APPENDIX B. OCC Pre-Application Response

Application no: 21/CH0010/Preaapp

Location: Land South of Green Lane, Chesterton

Transport Development Control

DRAWN:	JD	CHECKED:	IN	APPROVED:	TW
PROJECT No:	ITB14377	SCALE @ A3:	1:1000 / 1:500	DATE:	19.08.20
DRAWING No:	ITB14377-GA-001	REV:	F

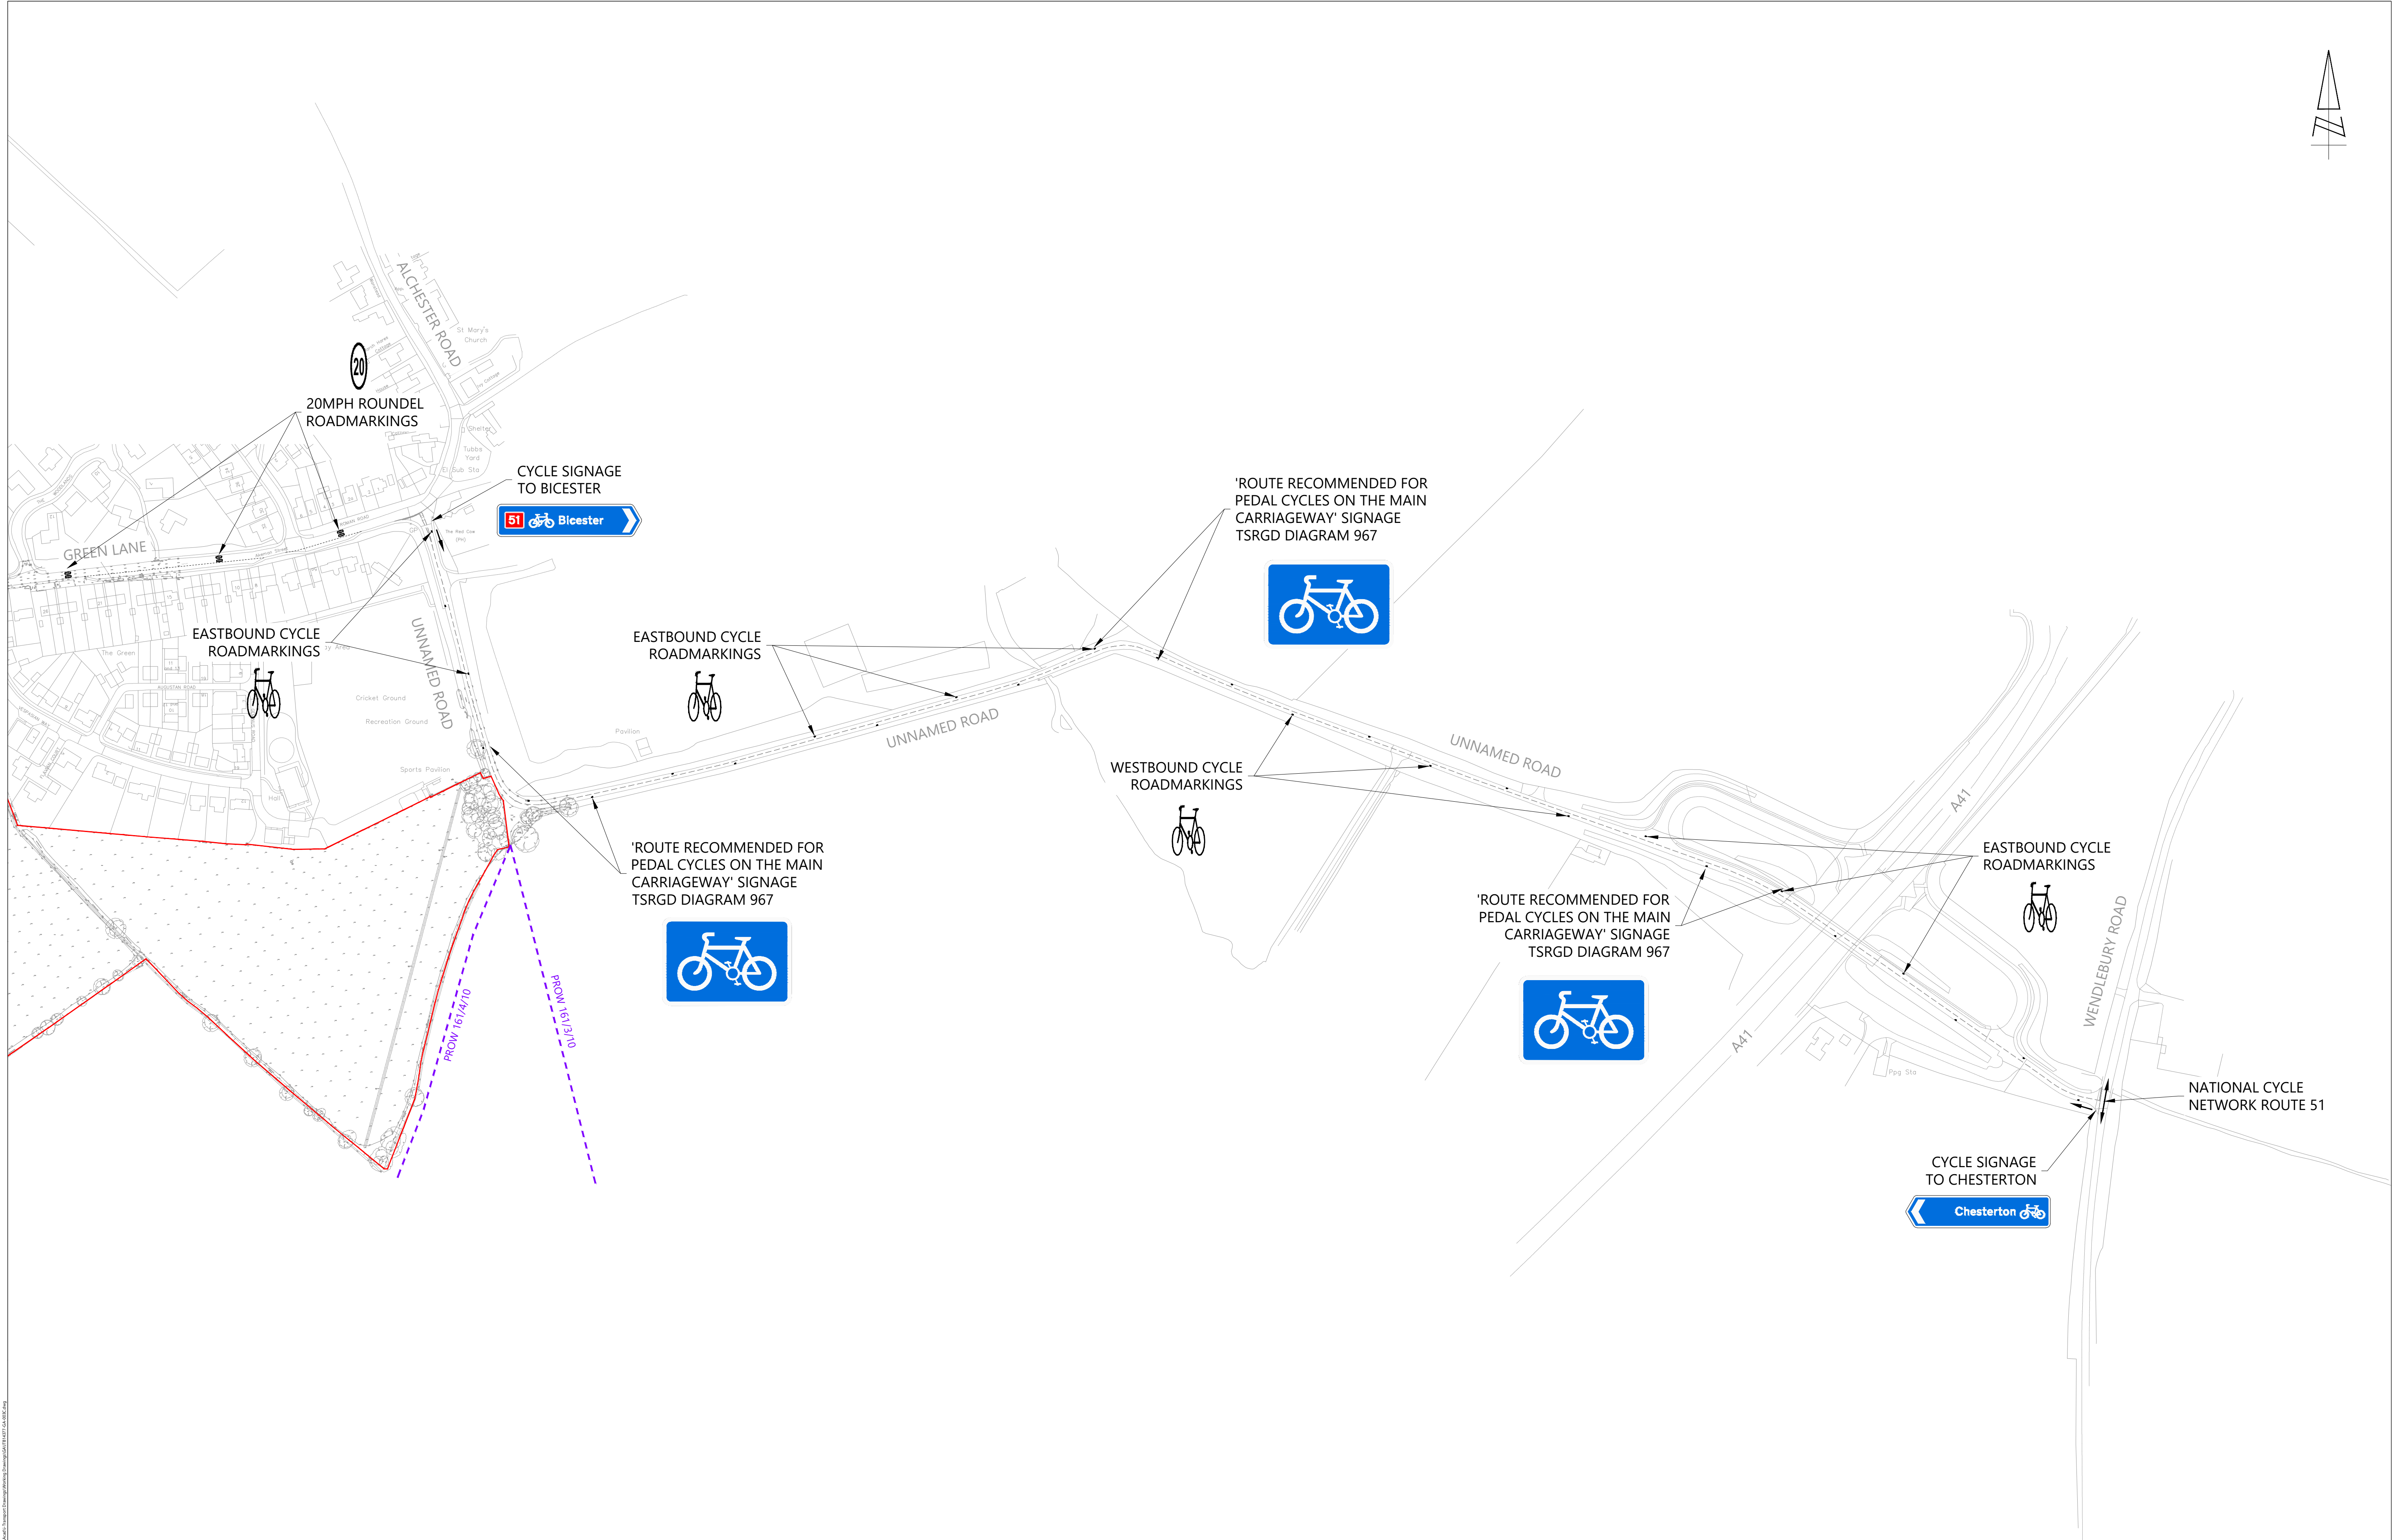
- Paragraph 3.4.4. Observed pre-pandemic data should be reviewed and presented to determine what uplift, if any, is required.
- Paragraph 4.2.2. The site access drawing shows a 2.0m margin on either side of the 5.5m carriageway. It is not clear what these are for, but they could entice pedestrians onto Green Lane at this point, which has no footway and should be discouraged for road safety reasons.

The proposed access arrangements are acceptable in principle, however the County would recommend that the 30mph speed limit be extended to enclose new site. New location of terminals and village signs would need to be outside of the visibility splay.

The site access drawing shows a 2.0m margin on either side of the 5.5m carriageway. It is not clear what these are for, but they could entice pedestrians onto Green Lane at this point, which has no footway and should be discouraged for road safety reasons.
